WEST SUSSEX COUNTY COUNCIL CONSULTATION

TO:	Arun District Council - FAO: Simon Davis
FROM:	WSCC - Highways Authority
DATE:	1 October 2021
LOCATION:	Land at Bayards, Level Mare Lane, Eastergate, PO20 3RZ
SUBJECT:	AL/113/21/OUT Outline application with all matters reserved, apart from access, for up to 69 No dwellings with access, parking, landscaping & associated works. This application is a Departure from the Development Plan.
RECOMMENDATION:	More Information

PROPOSED BUS IMPROVEMENTS (1:200)

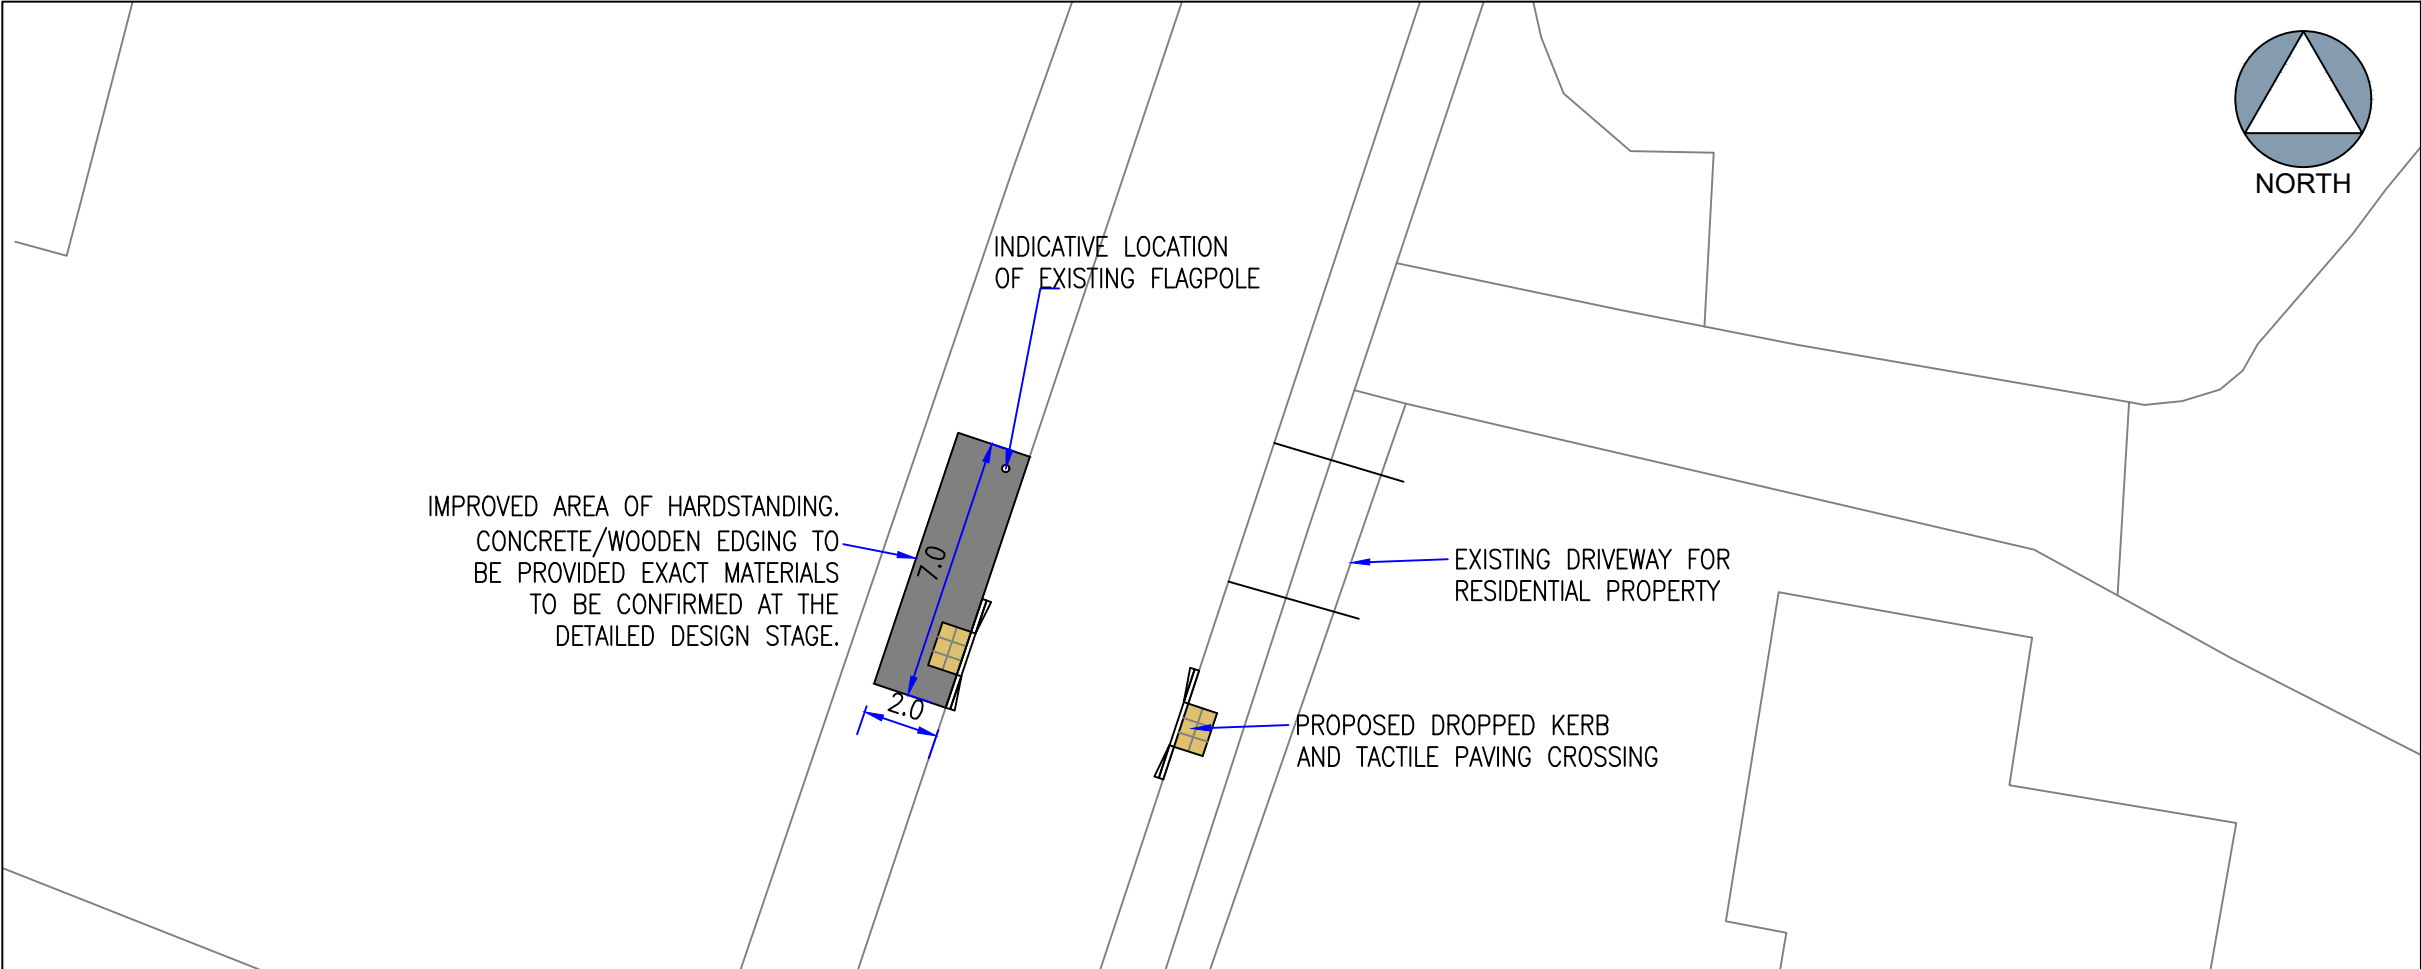
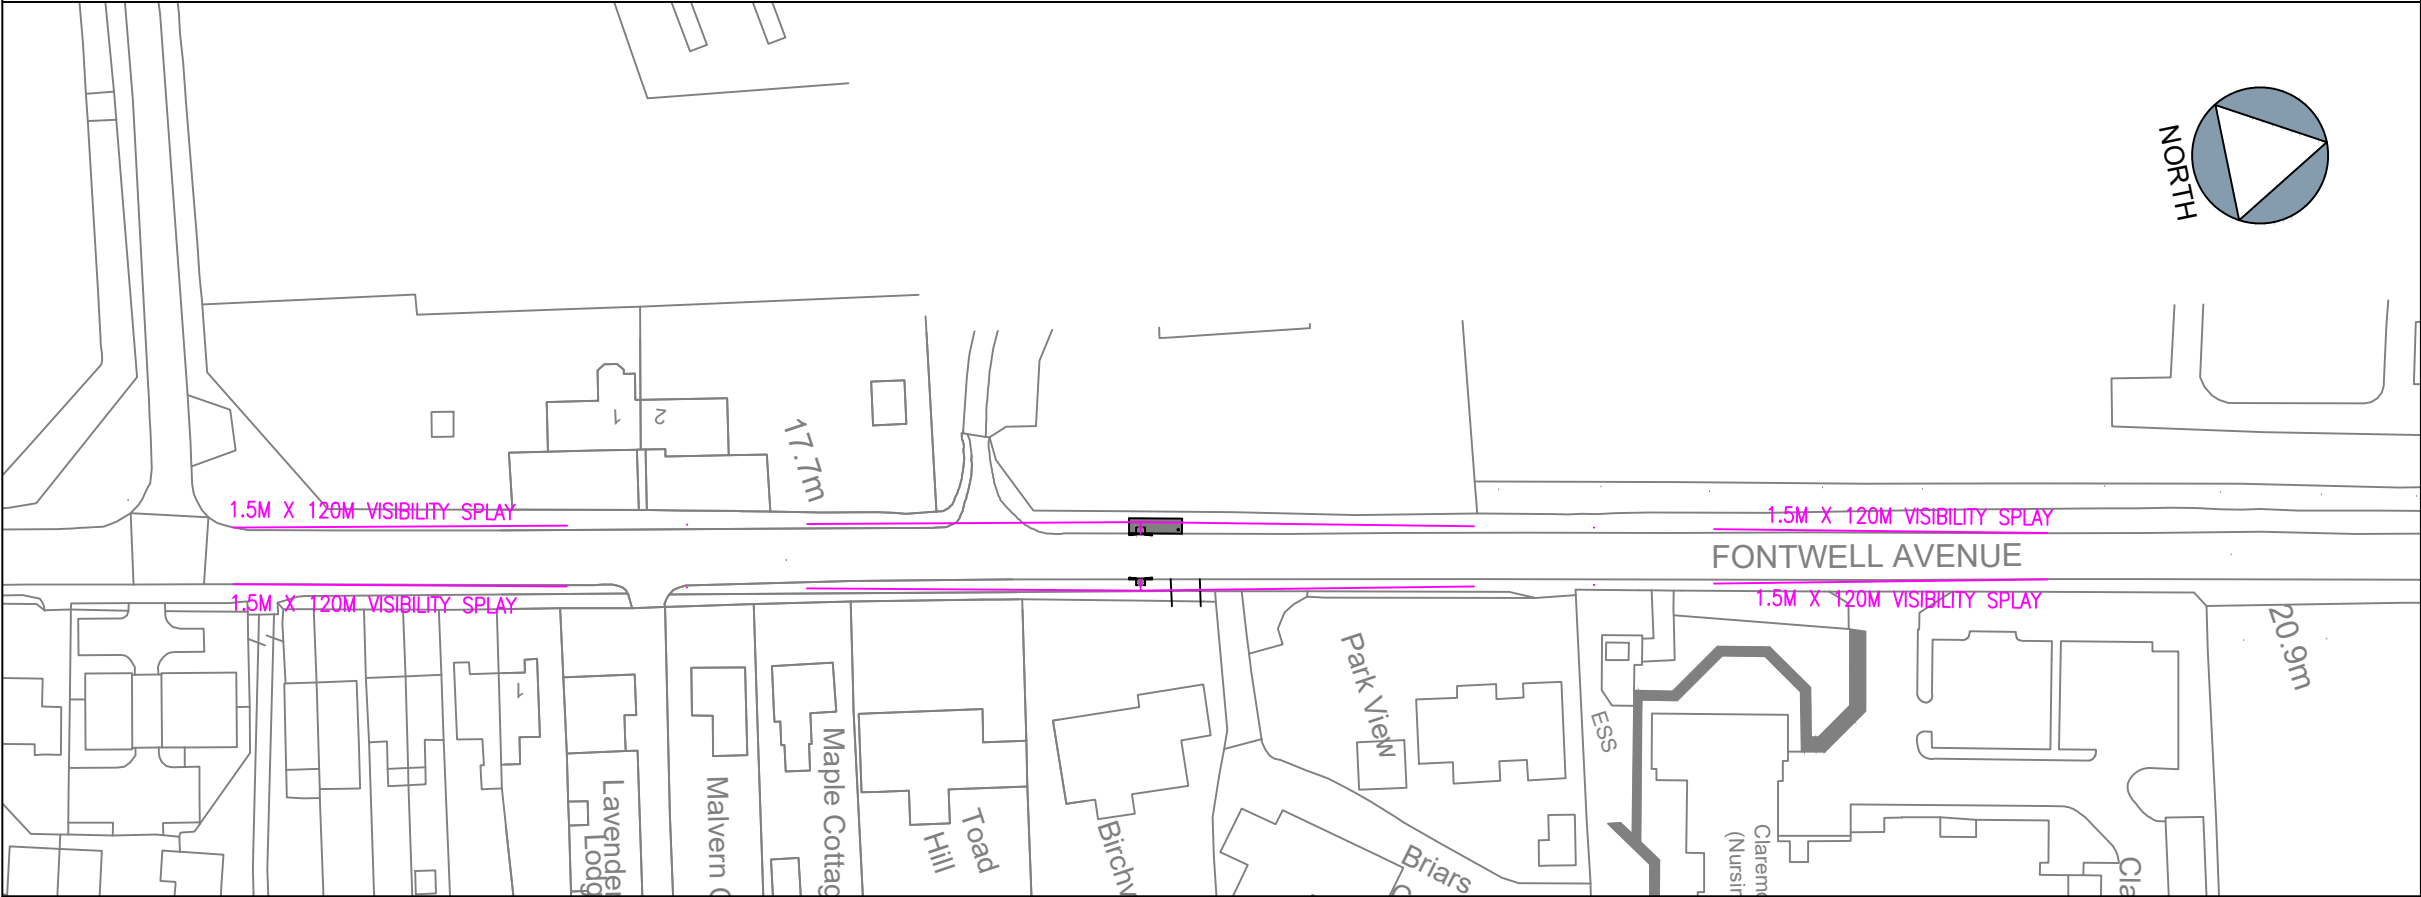
The nearest bus stops are on Fontwell Avenue (Level Mare Lane stops), north of the site. Whilst pedestrians could utilise the crossing point south of the site access, the northbound bus stop is located on an area of verge with no crossing. Hard standing and crossing point with dropped kerbs and tactile tiles would be welcomed here as an improvement. Provision of edging around the hardstand such as timber or concrete in order to make the maintenance of the area easier should also be explored along with bus cage markings. These works could be secured by minor s278 agreement.

Dropped kerb/tactile and hardstanding at Level Mare Lane bus stop.
